**Eastonville Road – Londonderry Dr. to Rex Rd.
Segment 2 Improvements
Stationing 47+00.00 – 79+31.62**

Final Drainage Report

January 2024

HR Green Project No: 201662.08

SHEET DRN 1  
 PROPOSED CONDITIONS - DRAINAGE MAP

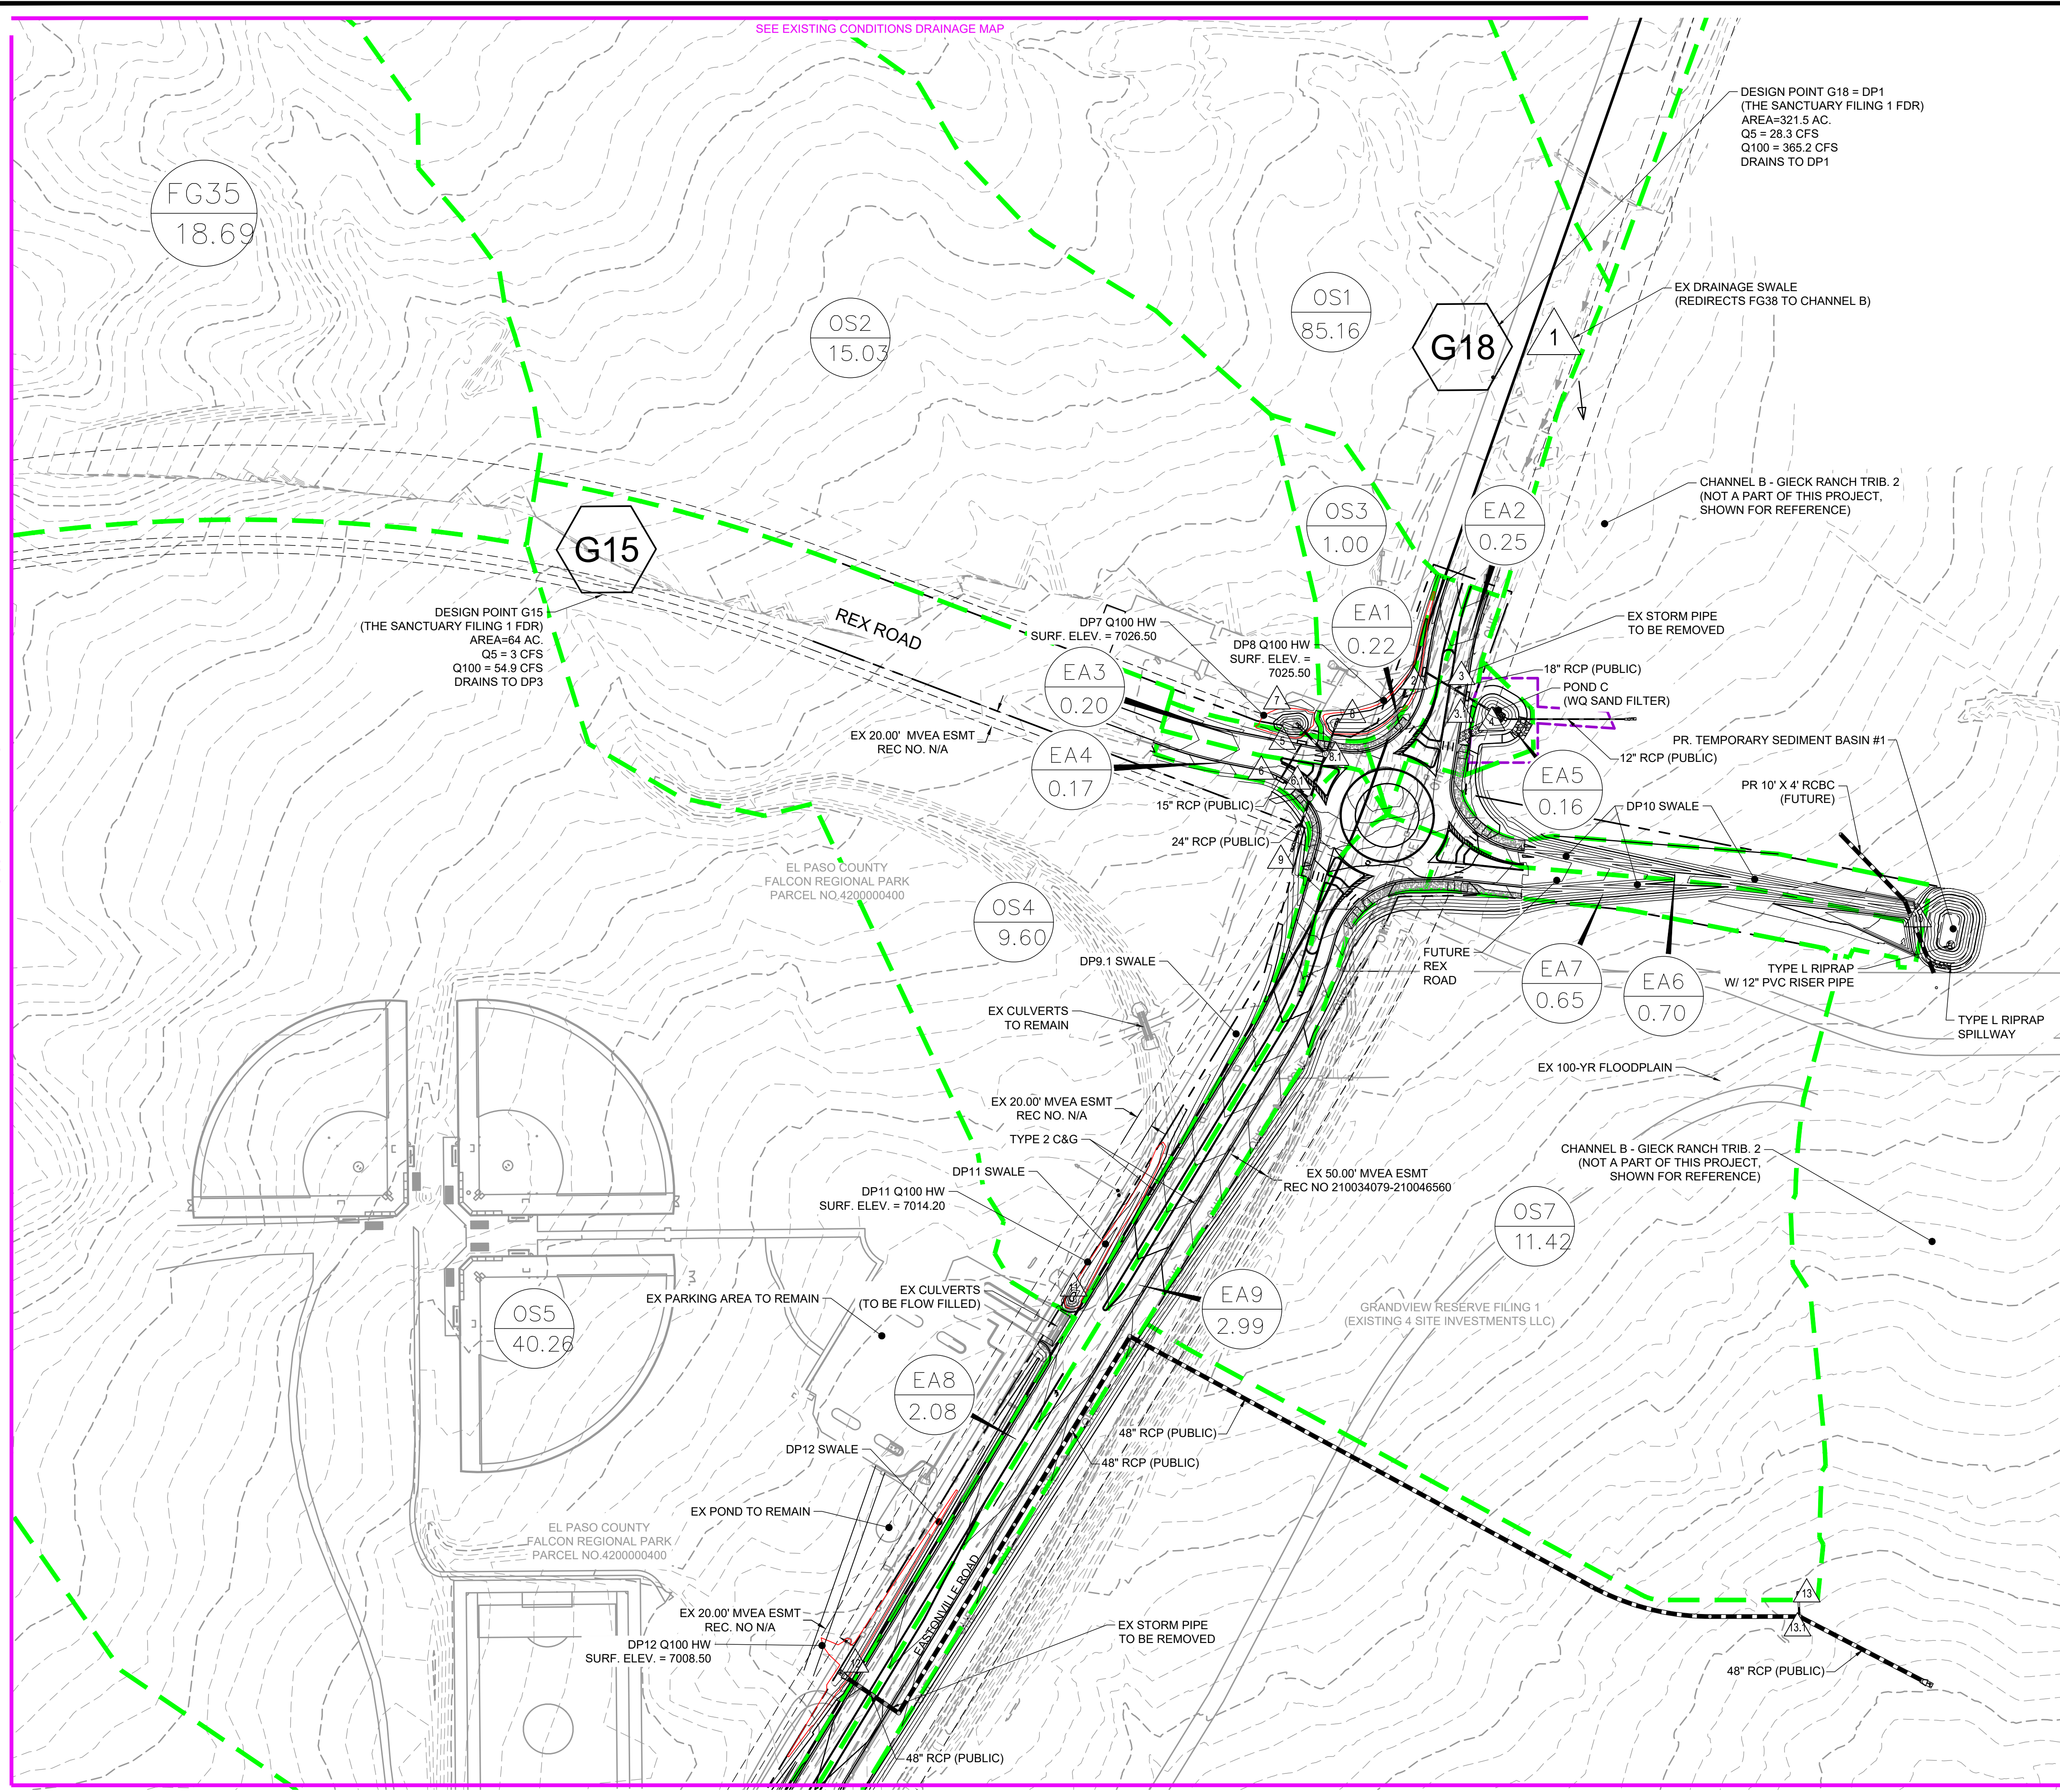
DP8.1? There is no DP9.1 shown on map or listed in hydrology spreadsheet

Should be Pond C

Label pond on drainage map

Basins OS2 - OS6, and the unnamed basins that are east of Eastonville Rd all have proposed soil disturbances within them, which all must be accounted for via WQ treatment or an applicable WQ exclusion. So please address this in the respective Basin paragraphs and create new proposed sub-basins as necessary.

EXISTING CONDITIONS - DRAINAGE MAP
SHEET DRN 1

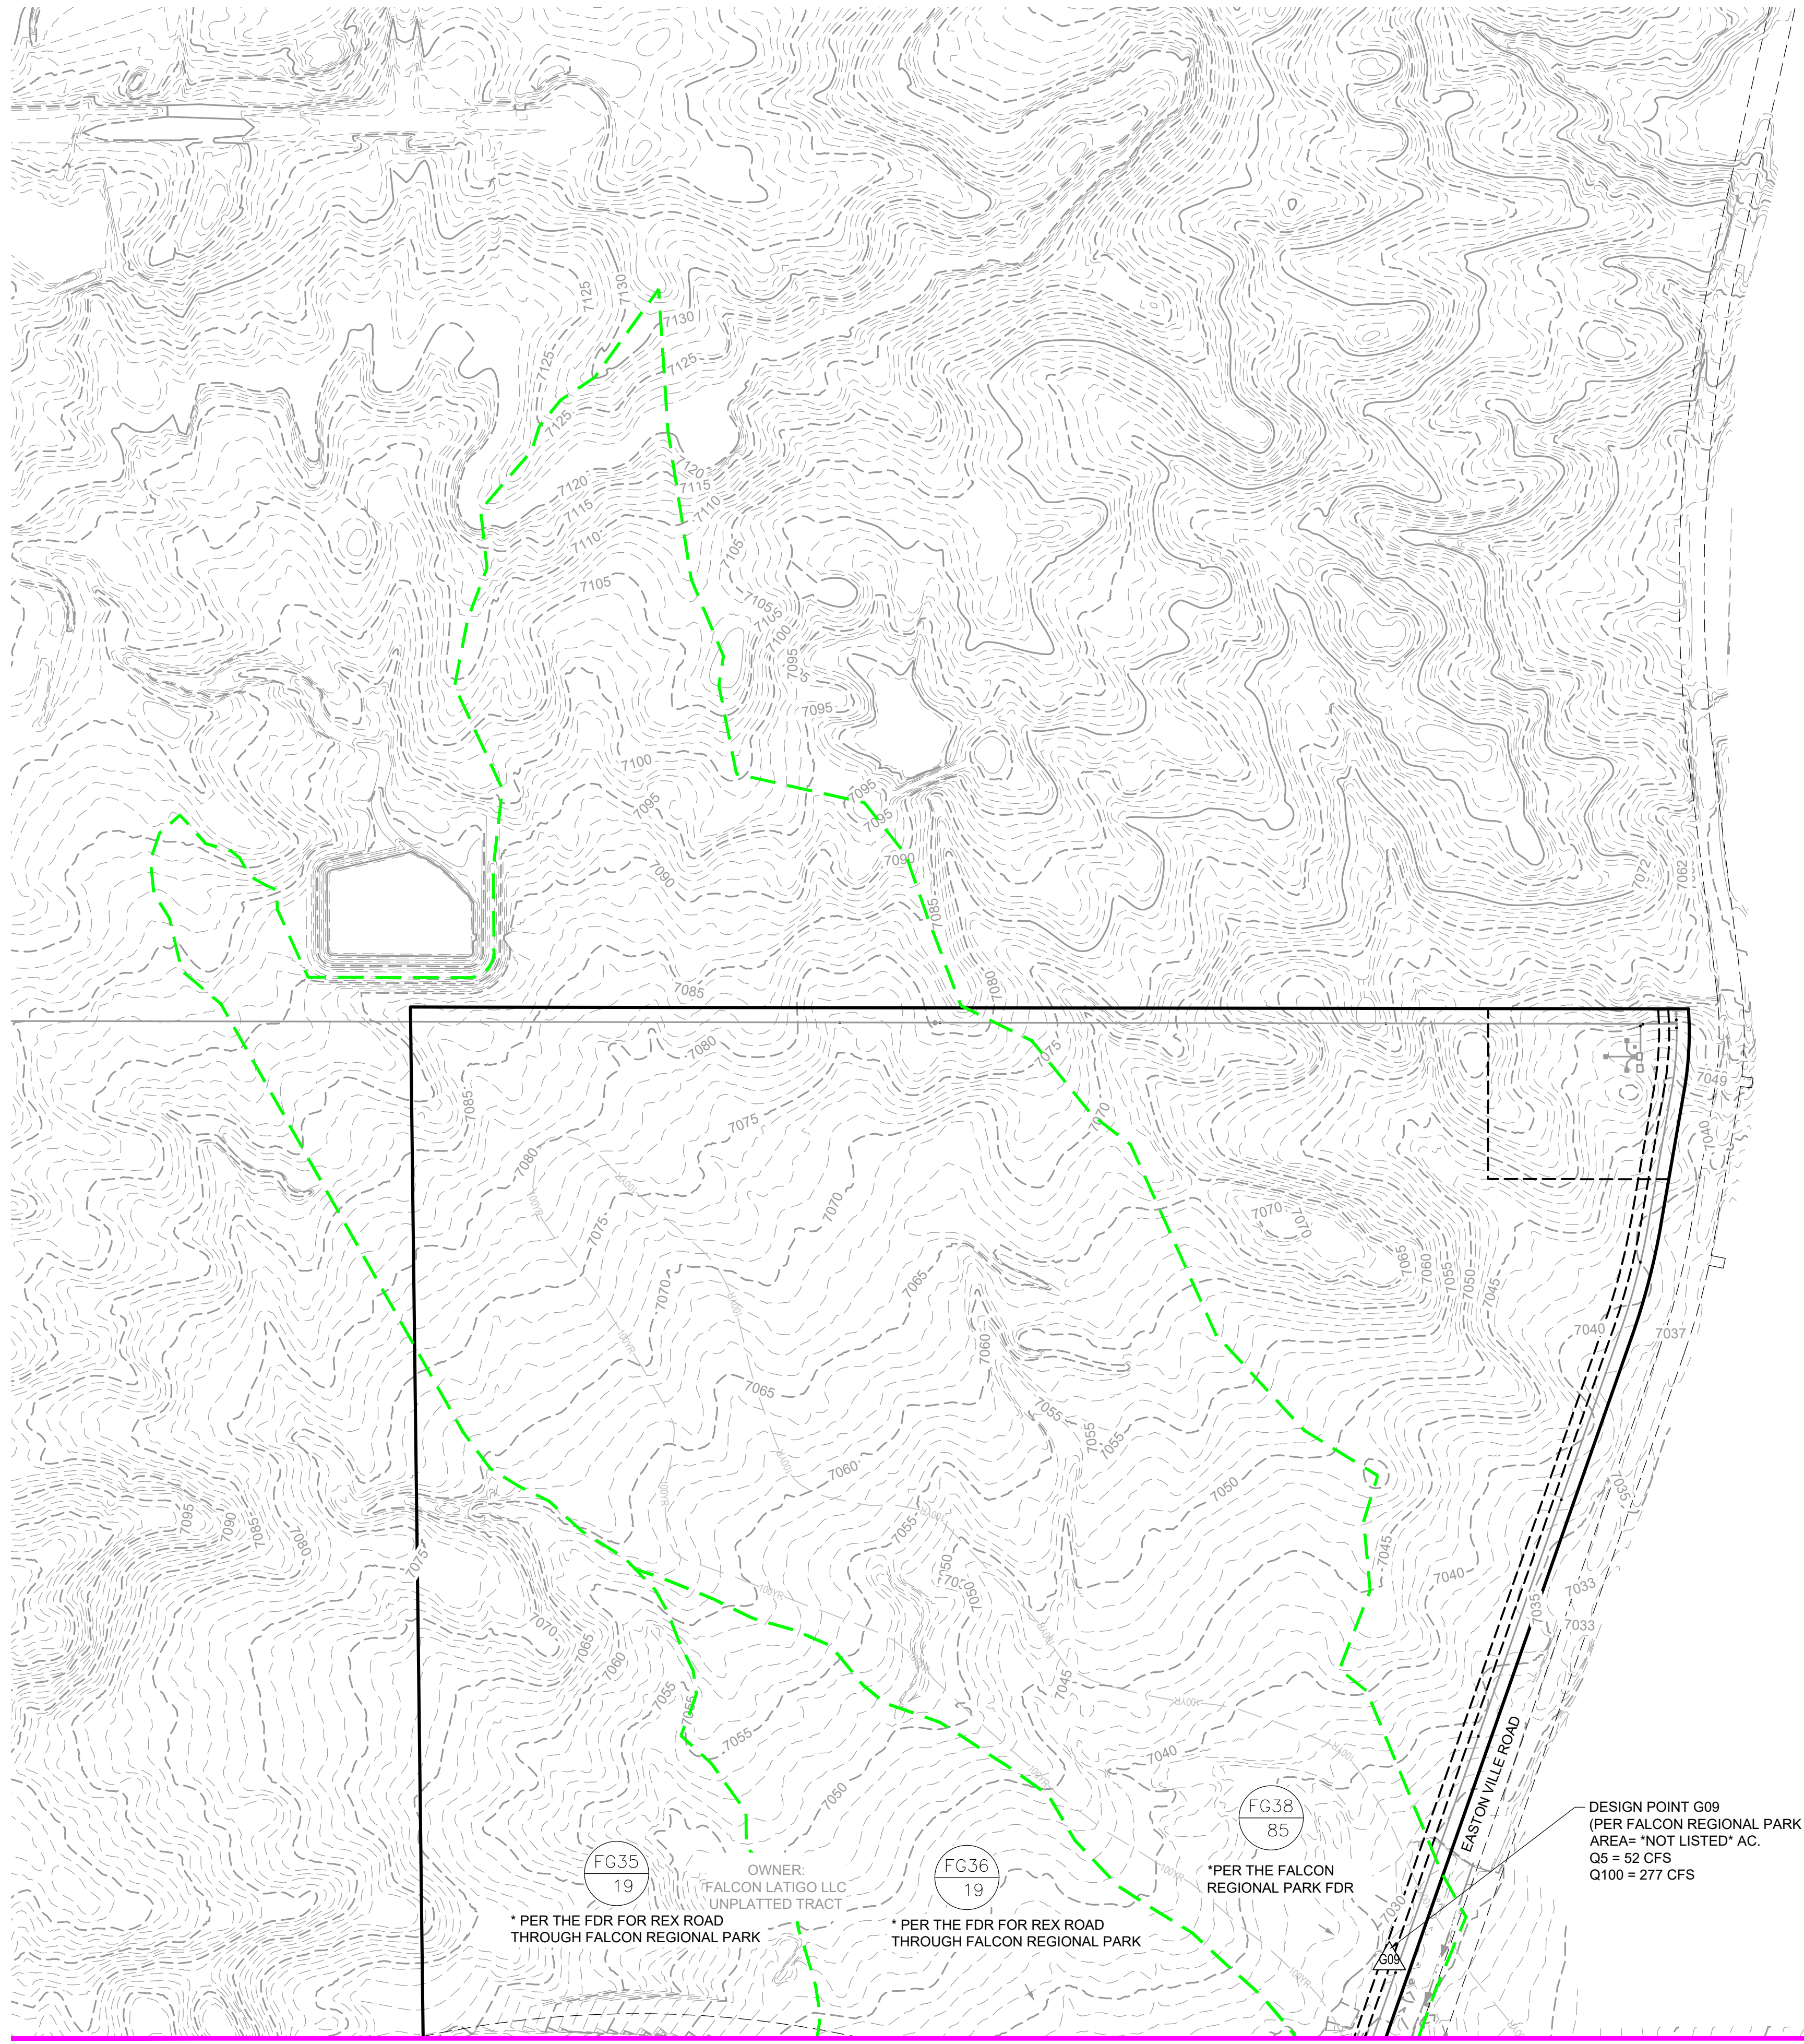
Show existing gas line on map. Did not see it.
